Response to Planning Application

From: Arun District Council Greenspace

Application ref: R/60/22/PL

Description: Extension and remodelling of existing public house to form hotel with 20 No bedrooms and associated parking and landscaping. This site is in CIL Zone 4 (Zero Rated) as other development.

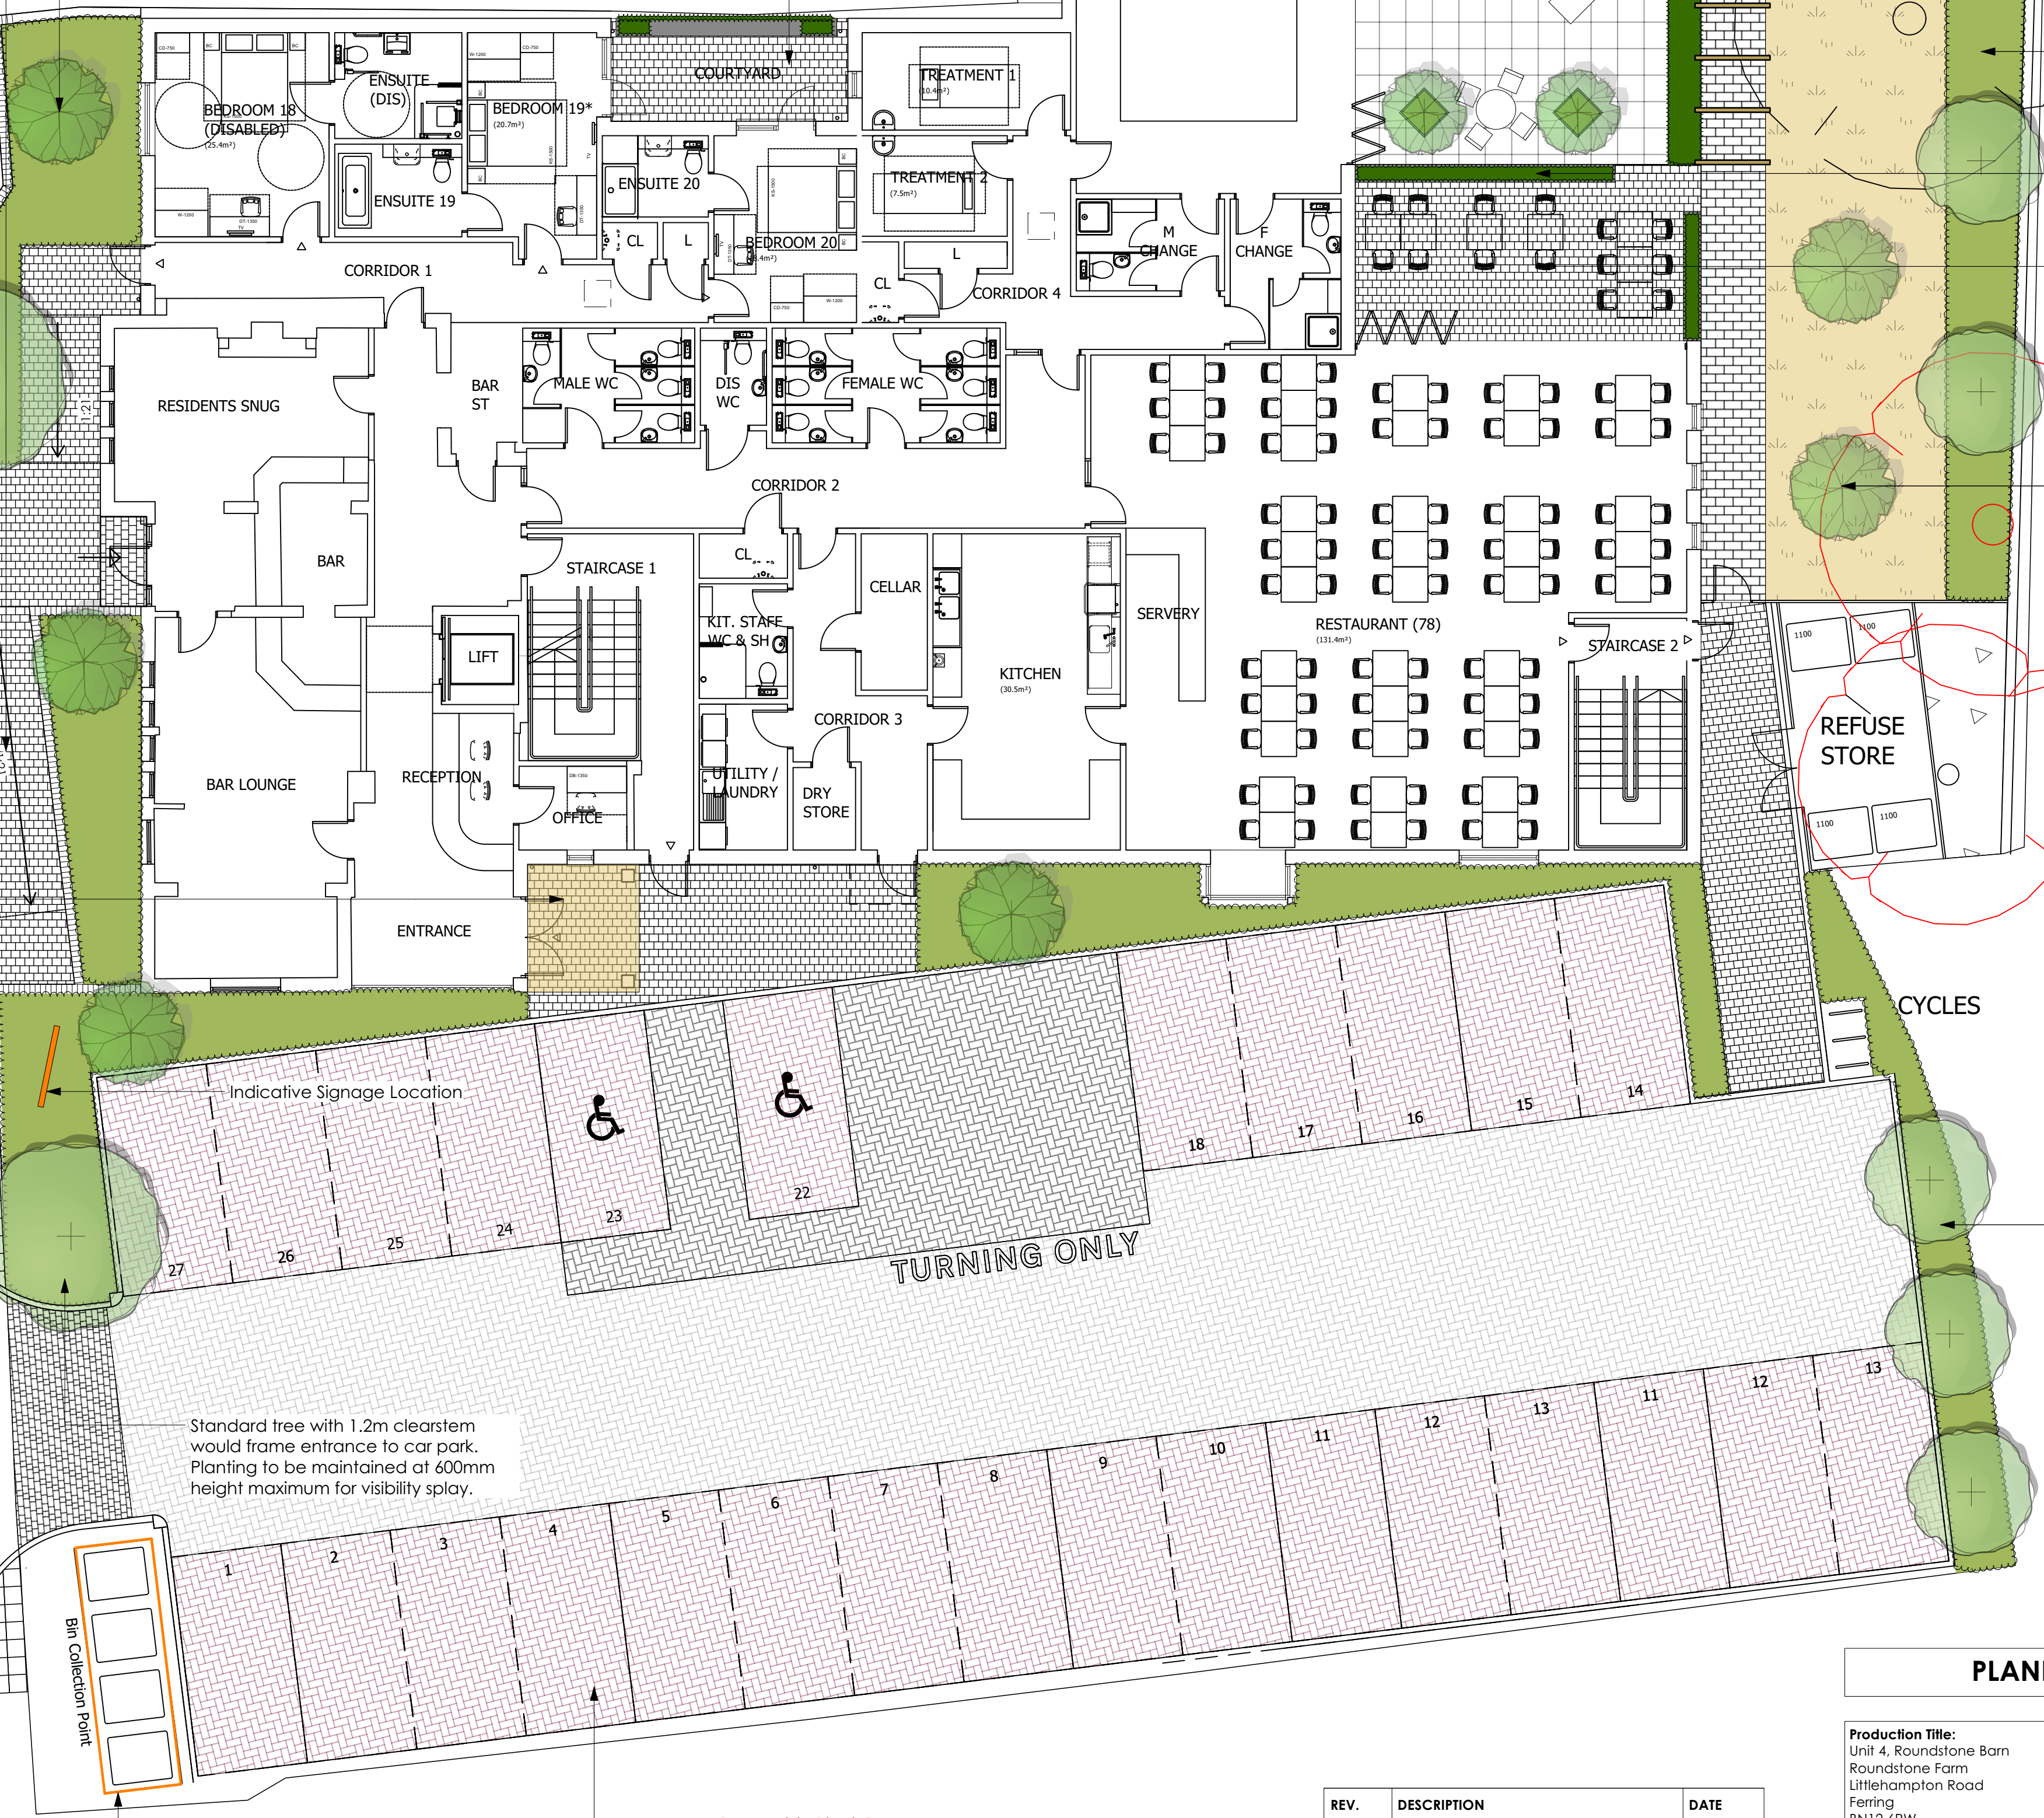
Any scheme must take into consideration the needs of the development along with the wider viewpoints. The indicative drawings have not provided any landscape consideration, this would need to be detailed and be appropriate for use and setting.

A full landscape scheme will need to be submitted for approval, or conditioned as part of any approval; detailing species choice, position, densities and size at time of planting. This should be plotted in plan and list form and in relation to the trees and vegetation to be retained so that a clear picture of the proposals can be seen. These details are required to ensure that appropriate mitigation is provided, maintaining and uncompromising the setting and ensuring that the proposals fit within the area of neighbouring properties. These will need to incorporate screening as required, adding to and enhancing the setting, benefiting the potential of the proposed developments usage.

Tree Care Consultancy

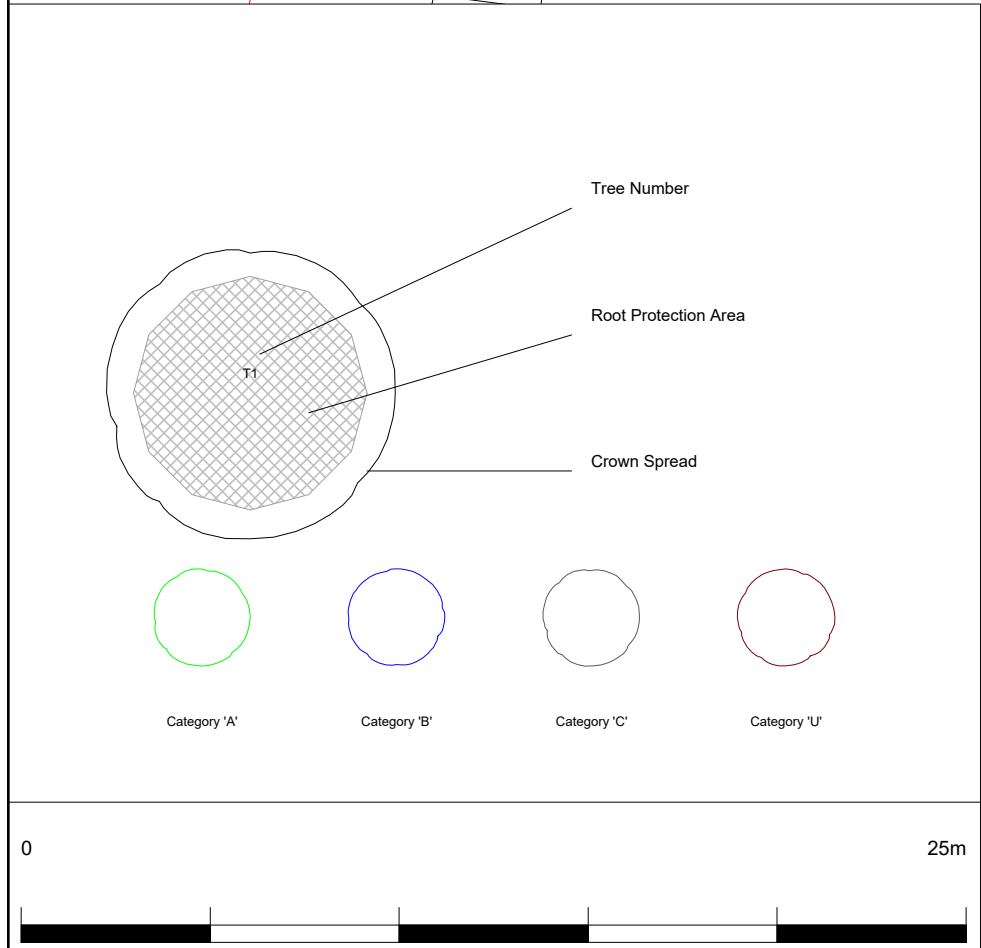
Two trees adjacent to the proposed refuse store have been indicated to facilitate the proposals within the plans submitted. Any tree removals required to facilitate the proposals, would need to be in consultation with the LPA Tree Officer. In relation to the nature of the proposals and its setting then a landscape scheme will need to be detailed, be appropriate for setting, provide mitigation where appropriate, provide

Any considered tree removal from this site should be agreed with Arun District Councils Tree Officer. Root protection Areas (RPA) should extend into the development site and to those in neighbouring land. Before construction, a tree protection scheme must be in place for any retained trees including trees whose root protection areas fall within the construction zone from neighbouring land.
